### INTAKE SCREENING COMMENTS RESPONSE

Permit Number **2208-260**

Project Address 8455 SE 83<sup>RD</sup> ST.  
Mercer Island, WA 98040

Subject **Response to Building Permit Intake Screening Comments**

NOTE: REFER TO PLAN C10 FOR TREE PROTECTION FENCING INFORMATION, AND DIAGRAM 5/TS-4 FOR TREE PLANTING PLAN

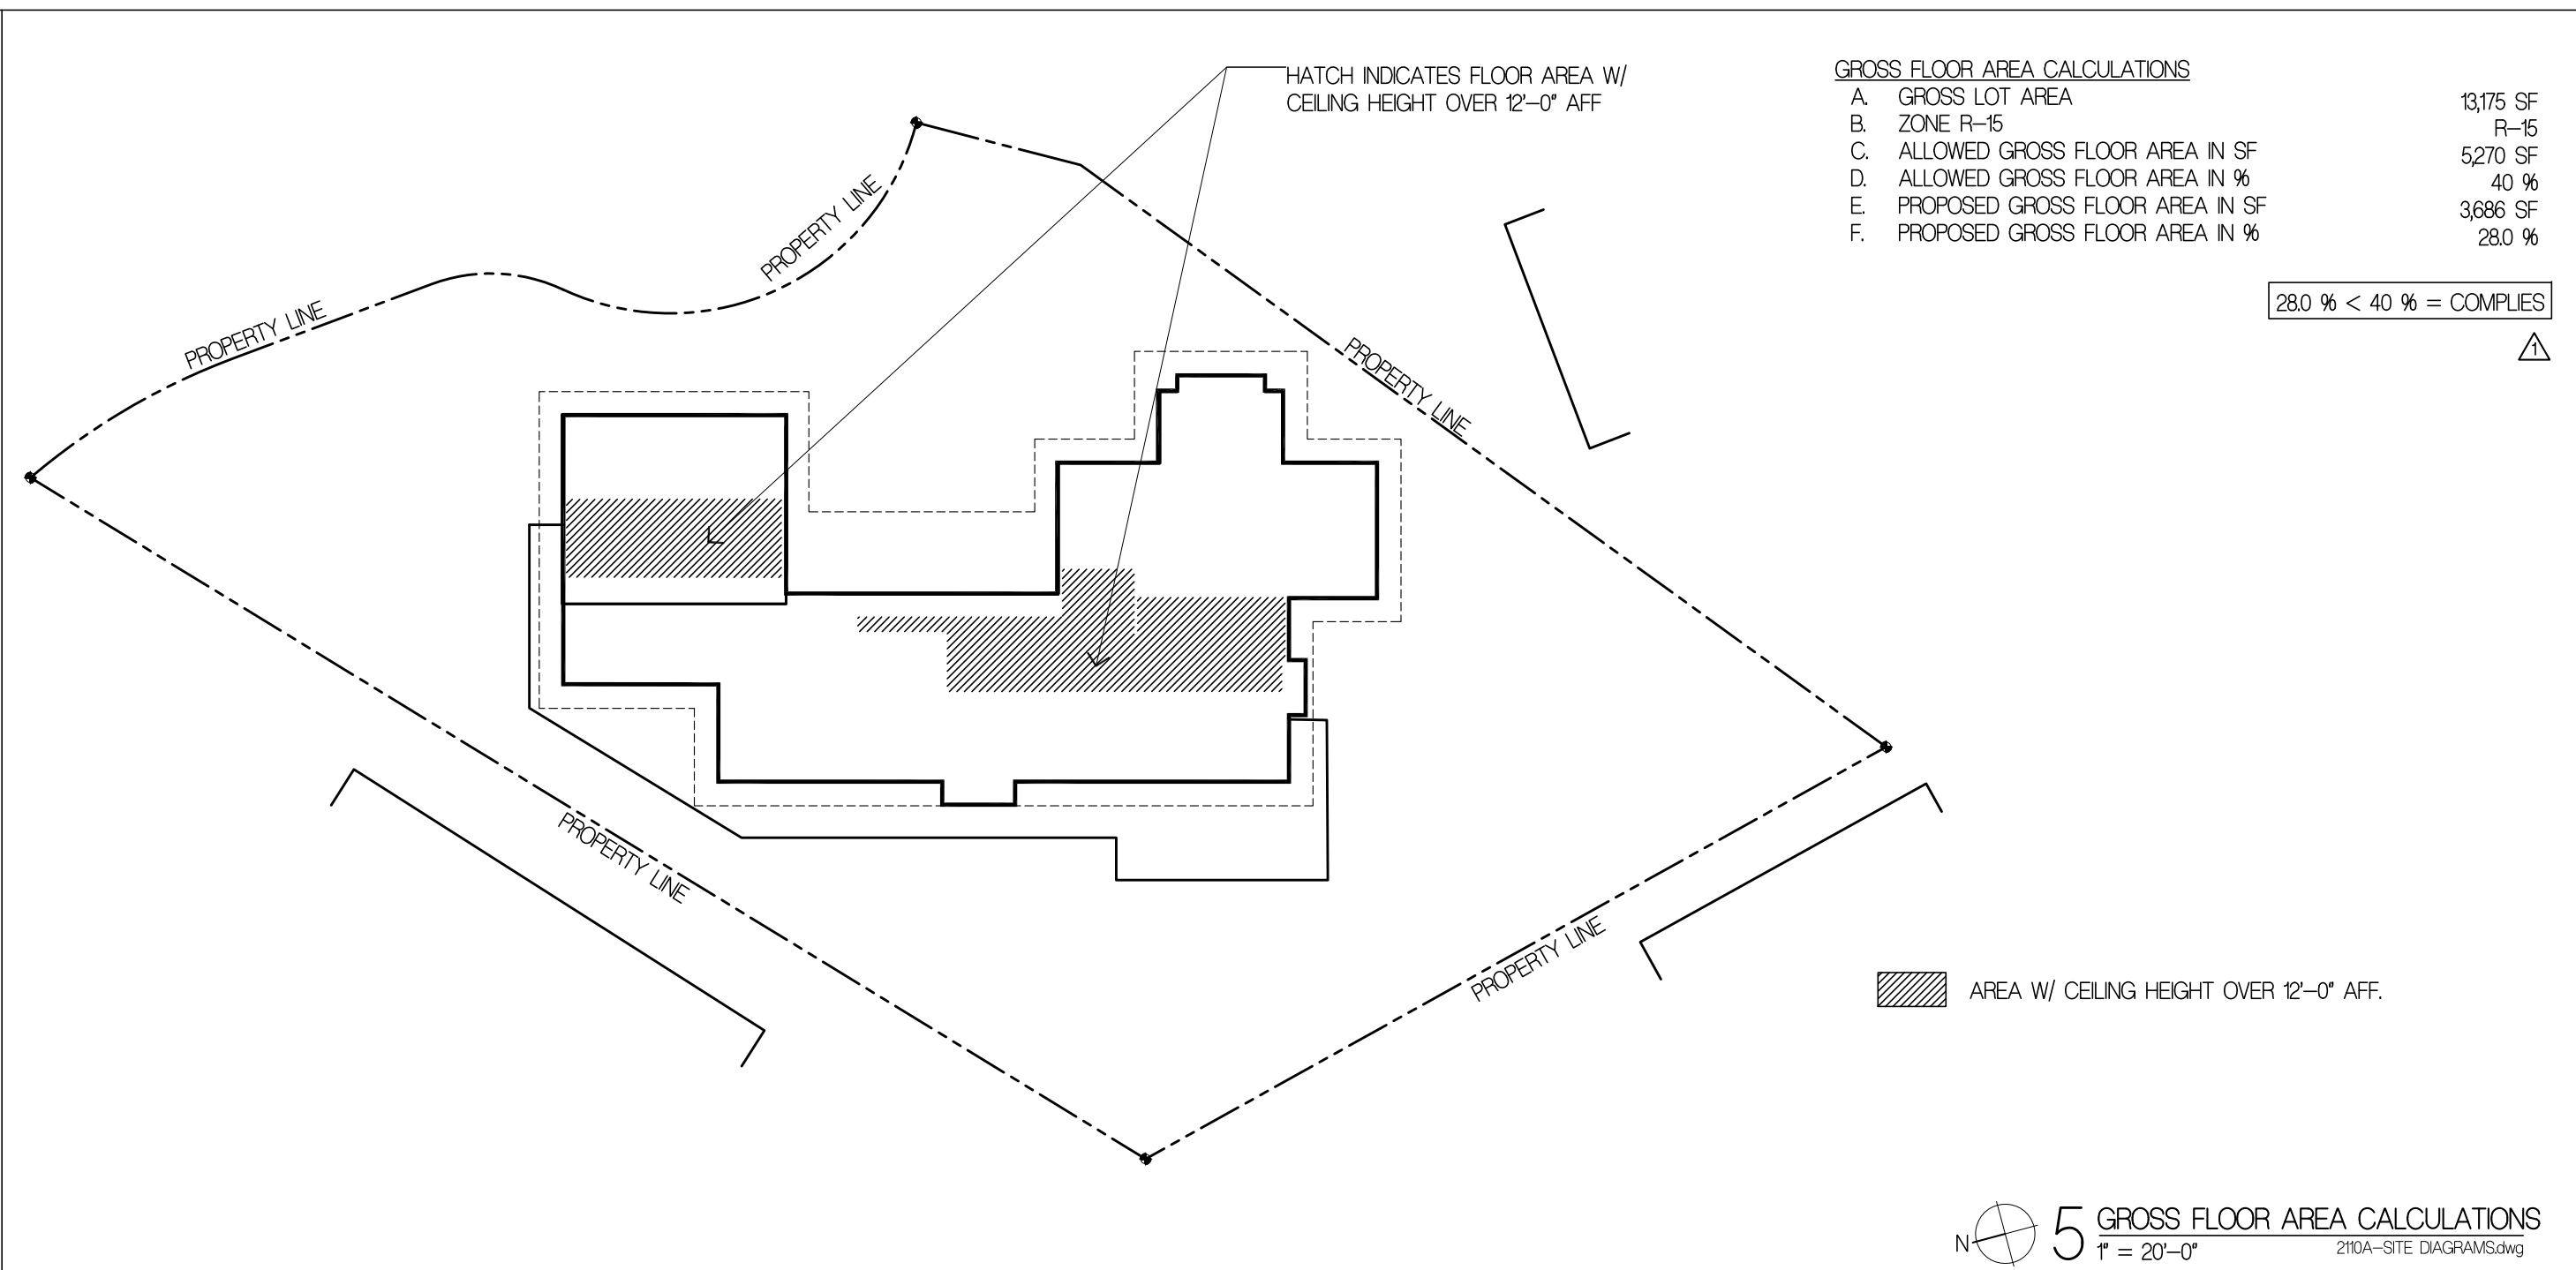
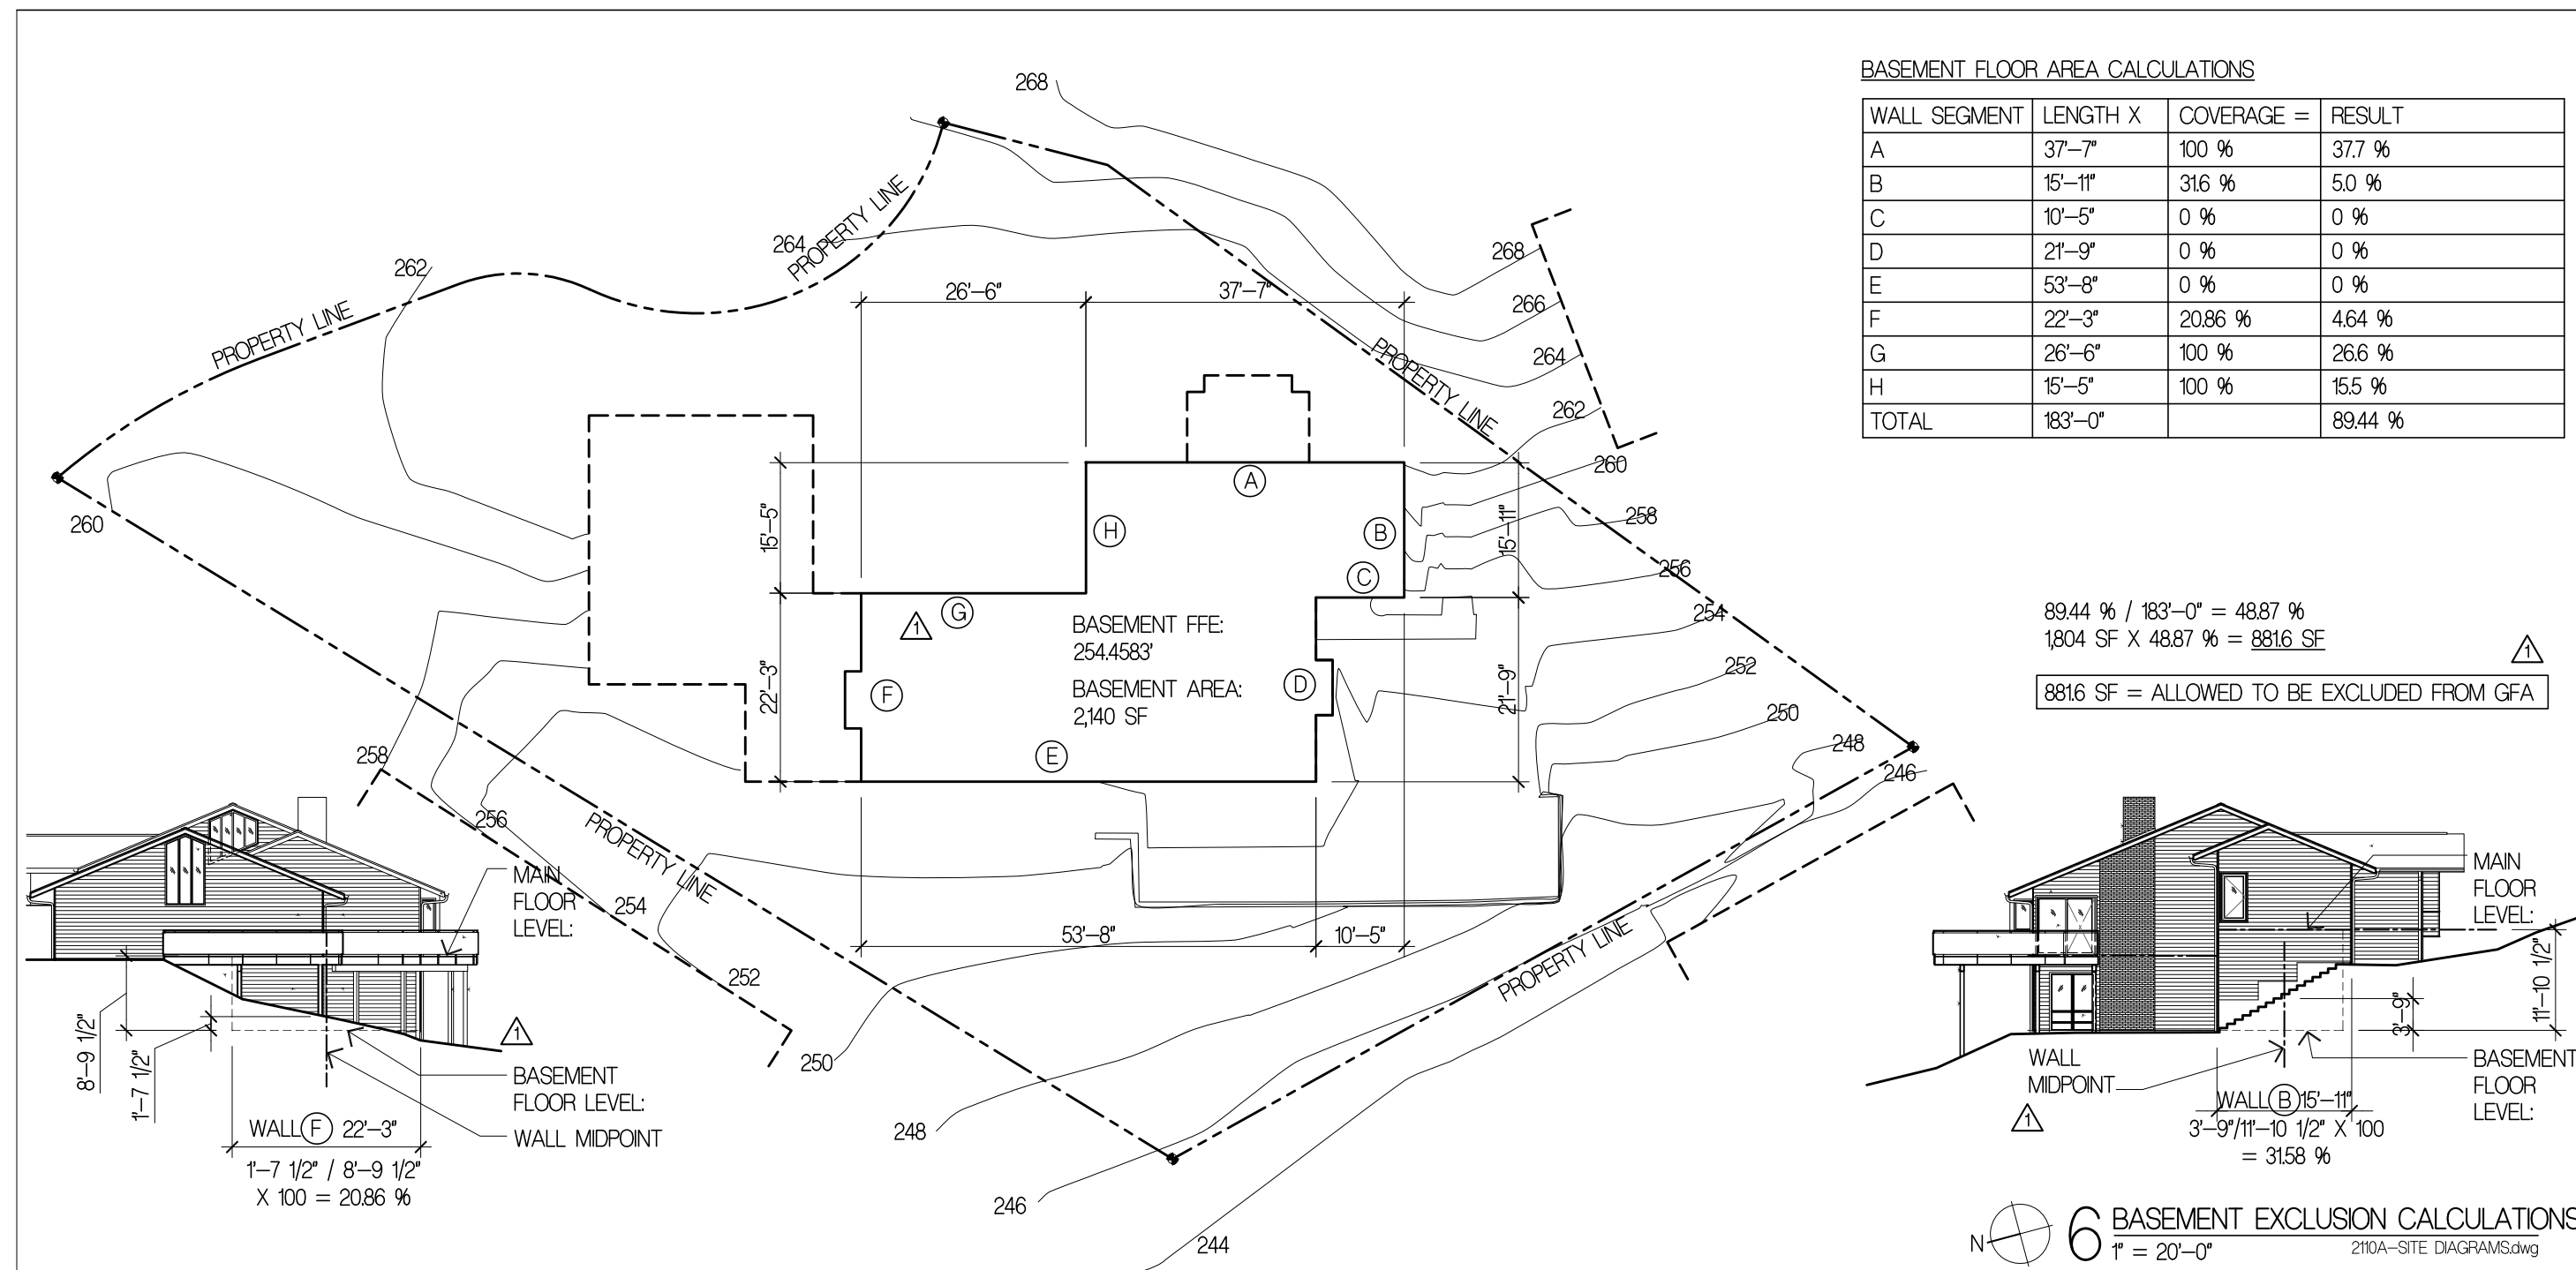
1. **Site Plan:**  
Response: As directed in the comment, Driveway length & widths have been noted on TS-2, Site Plan. The 2 minimum parking spaces required – this has been noted on TS-1 Project Information sheet under 'Zoning Information'.

4. **Critical Area on Plan:**  
Response: The dashed line showing the Critical Area shown on Site Plan sheet TS-2 has been made darker to enhance the visibility. The note is located near the bottom left of the drawing sheet.

6 EXTERIOR ALTERATION WALL CALCULATIONS
 T = 20'-0" 210A-SITE DIAGRAMS.dwg

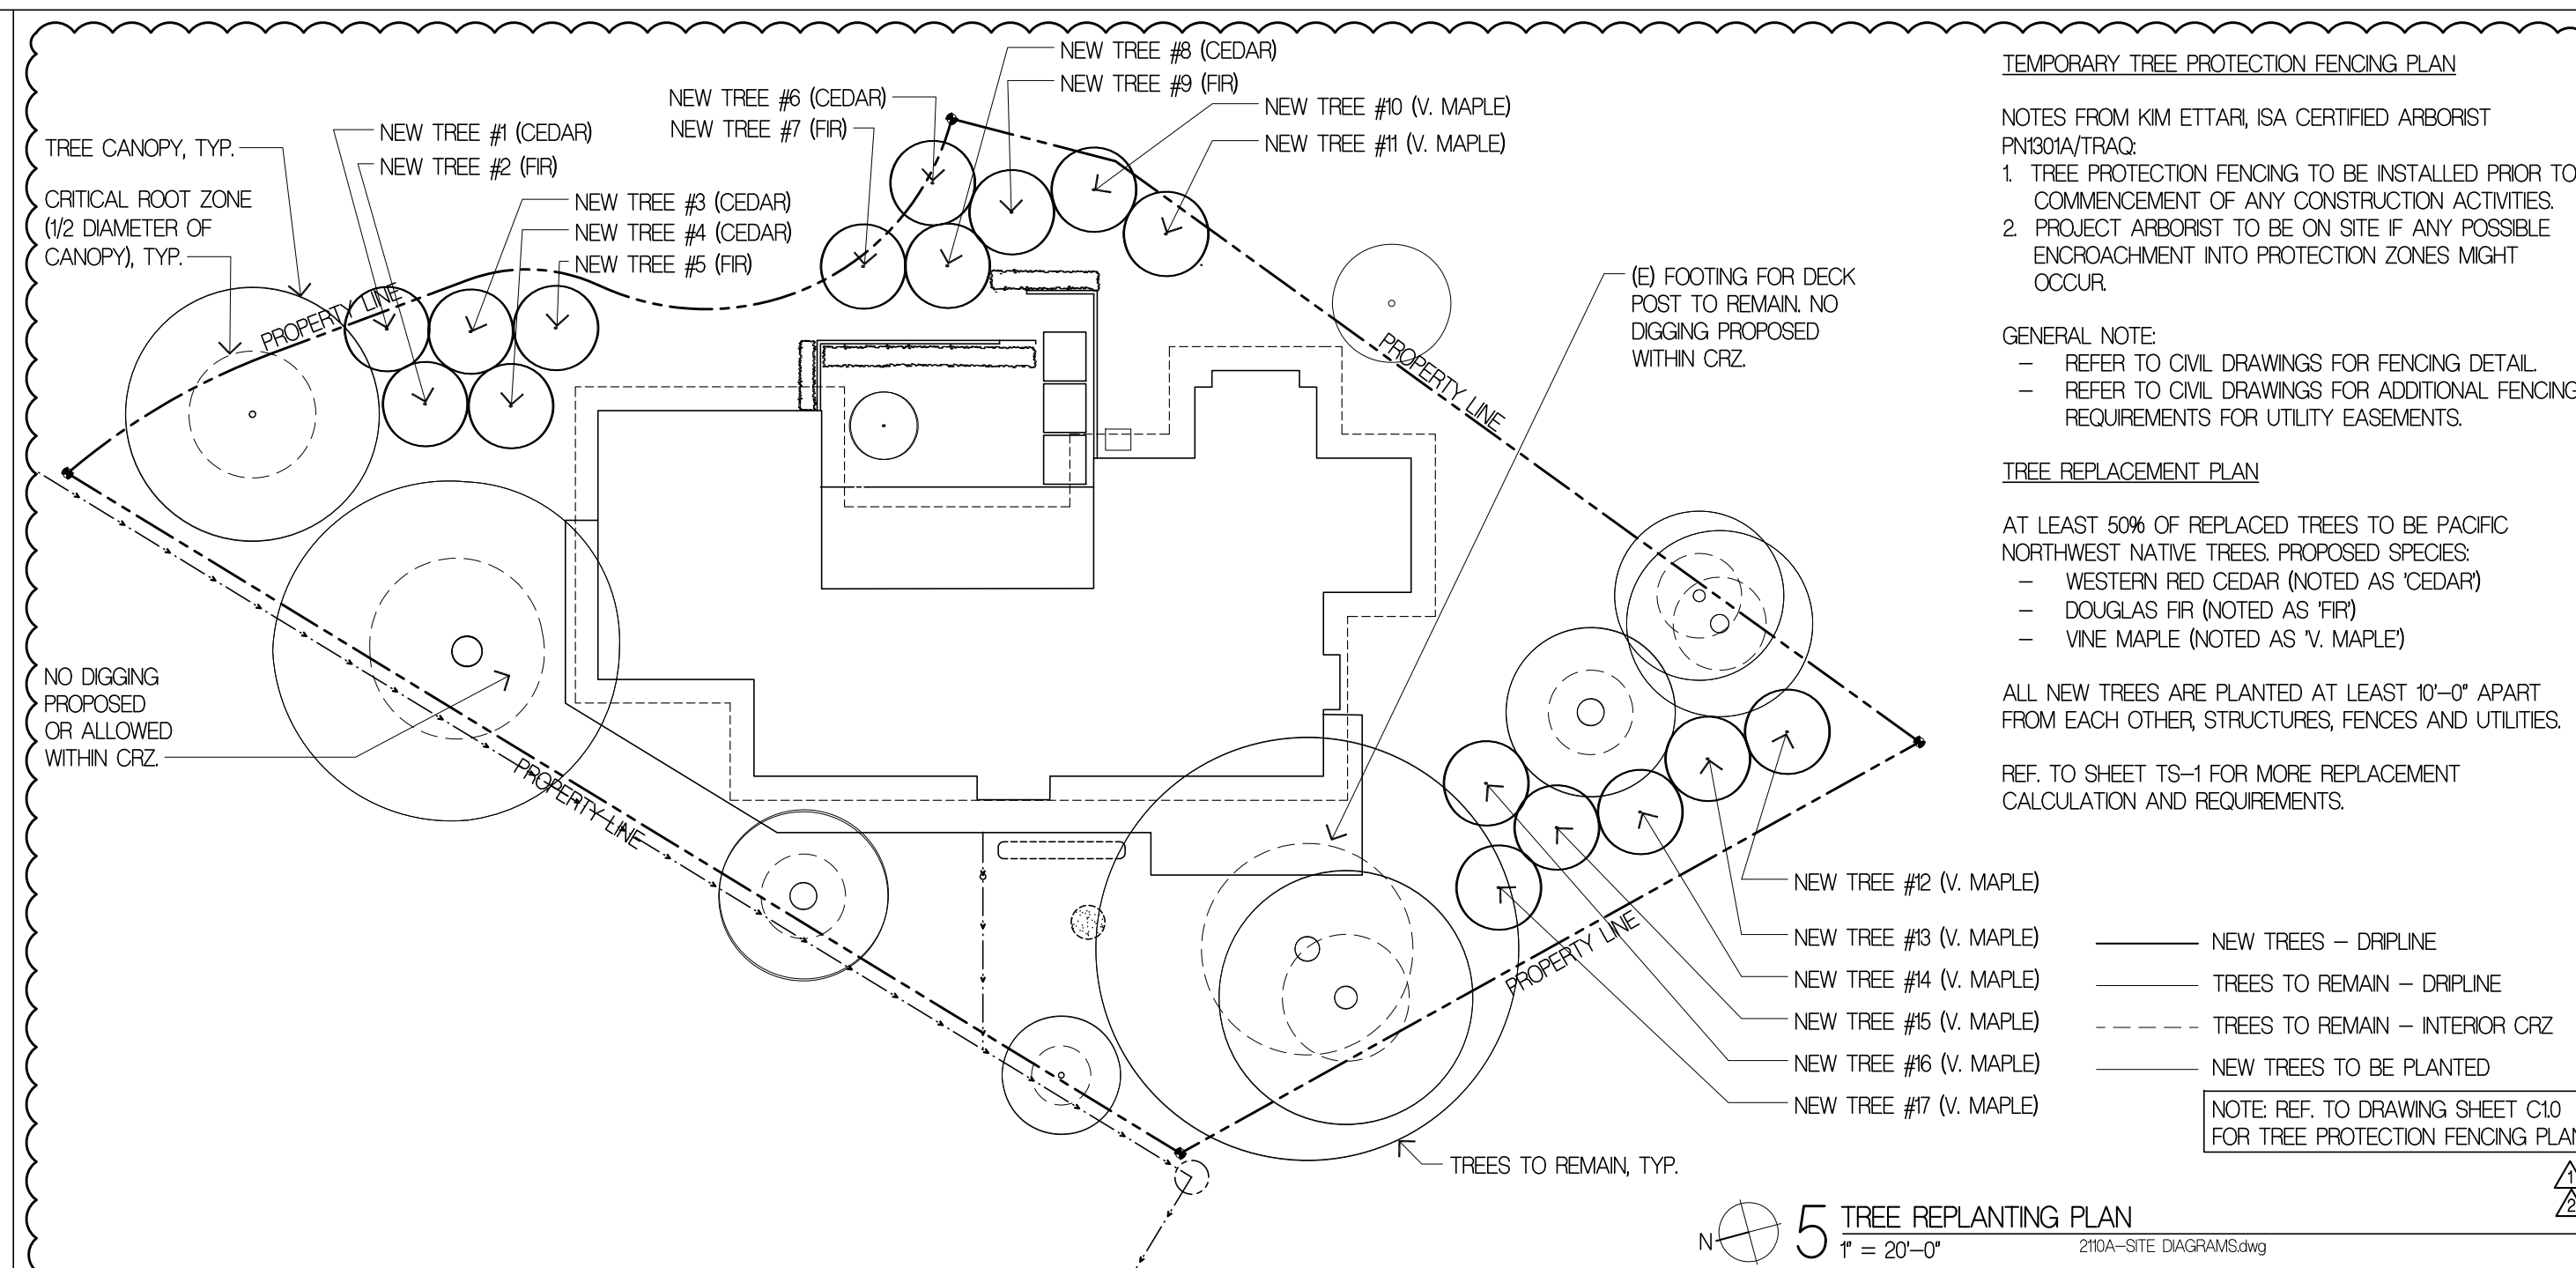
2. **Exterior Wall Alteration Calcs:**  
Response: As directed in the comment, we added calculations to show less than 40% of the existing structure area is being altered. Please refer to 6/TS-4 Site Diagram.
